SUBJECT: Engineering Review Comment
Mountain View Electric Association Inc. (MVEA)

Project Name: Grandview Reserve Filing 1 – Final Plat

Project Number: SF2311

A PORTION OF THE SOUTHWEST QUARTER OF SECTION 21, AND A PORTION OF THE NORTHWEST QUARTER OF SECTION 28, TOWNSHIP 12 SOUTH, RANGE 64 WEST OF THE 6TH PRINCIPAL MERIDIAN, COUNTY OF EL PASO, STATE OF COLORADO

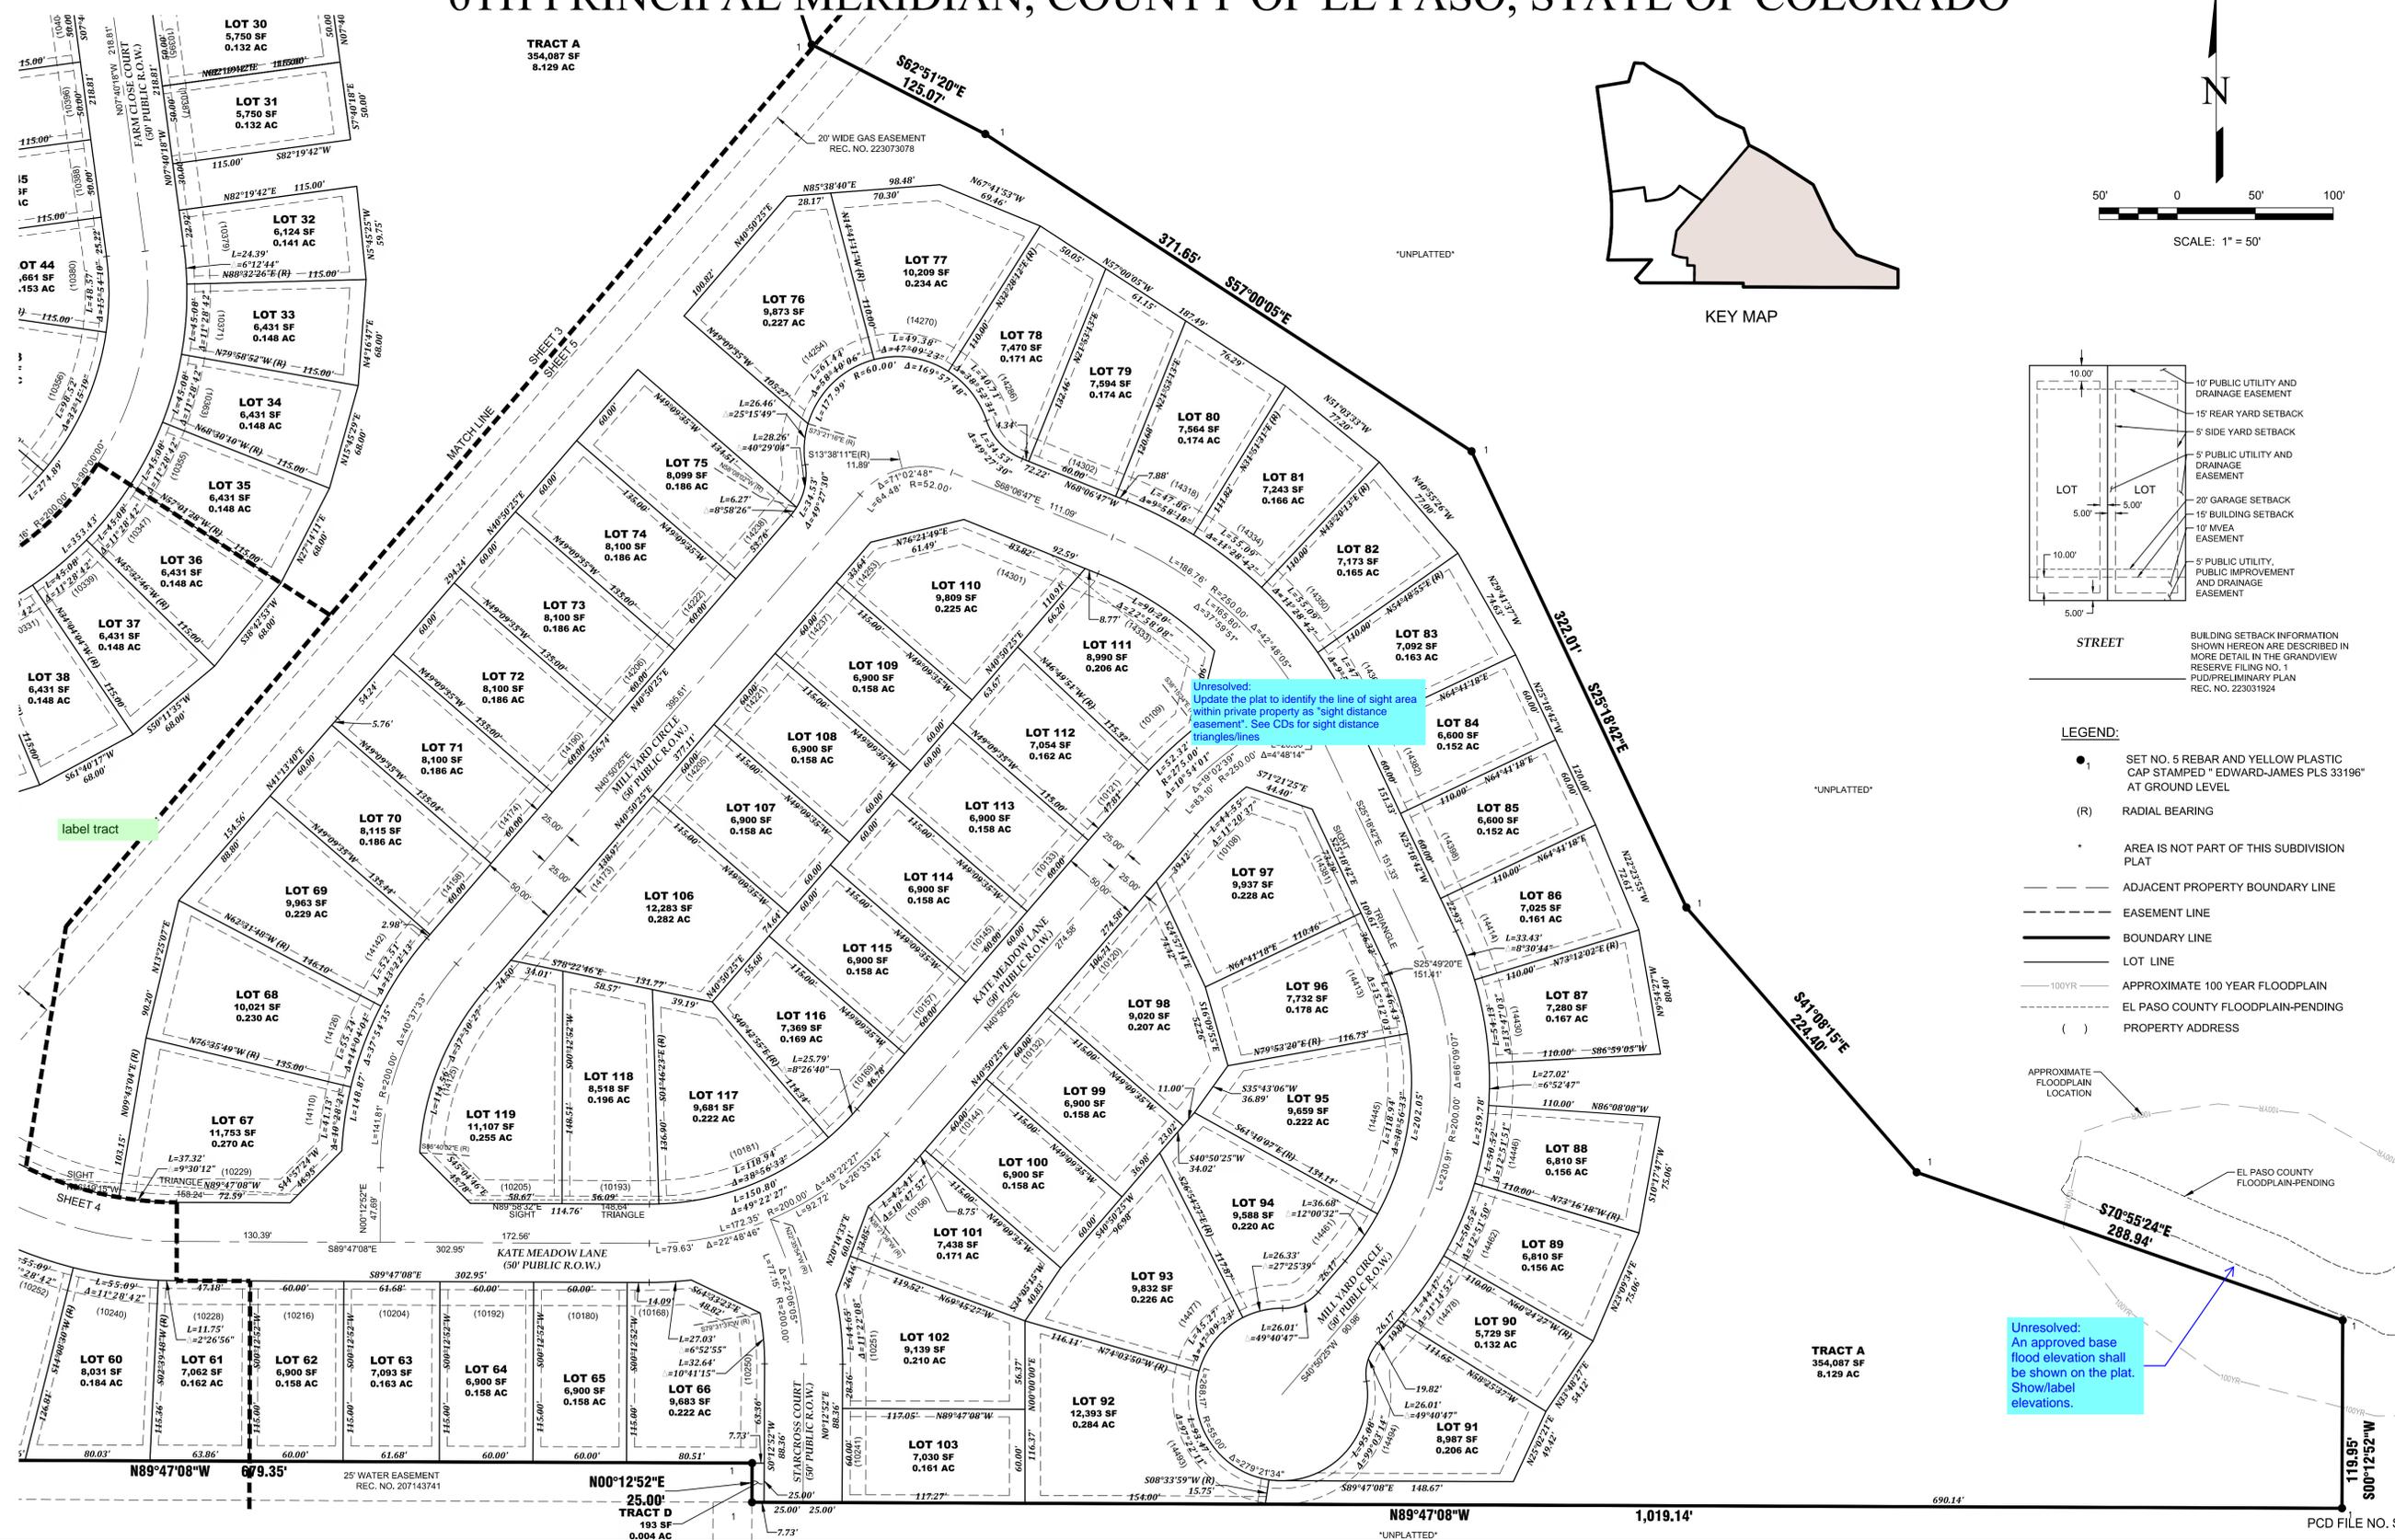
MVEA does not object to the easements shown on General Note #8. MVEA does request that Utilities be added to the Tract Table for consistency with General Notes 14.
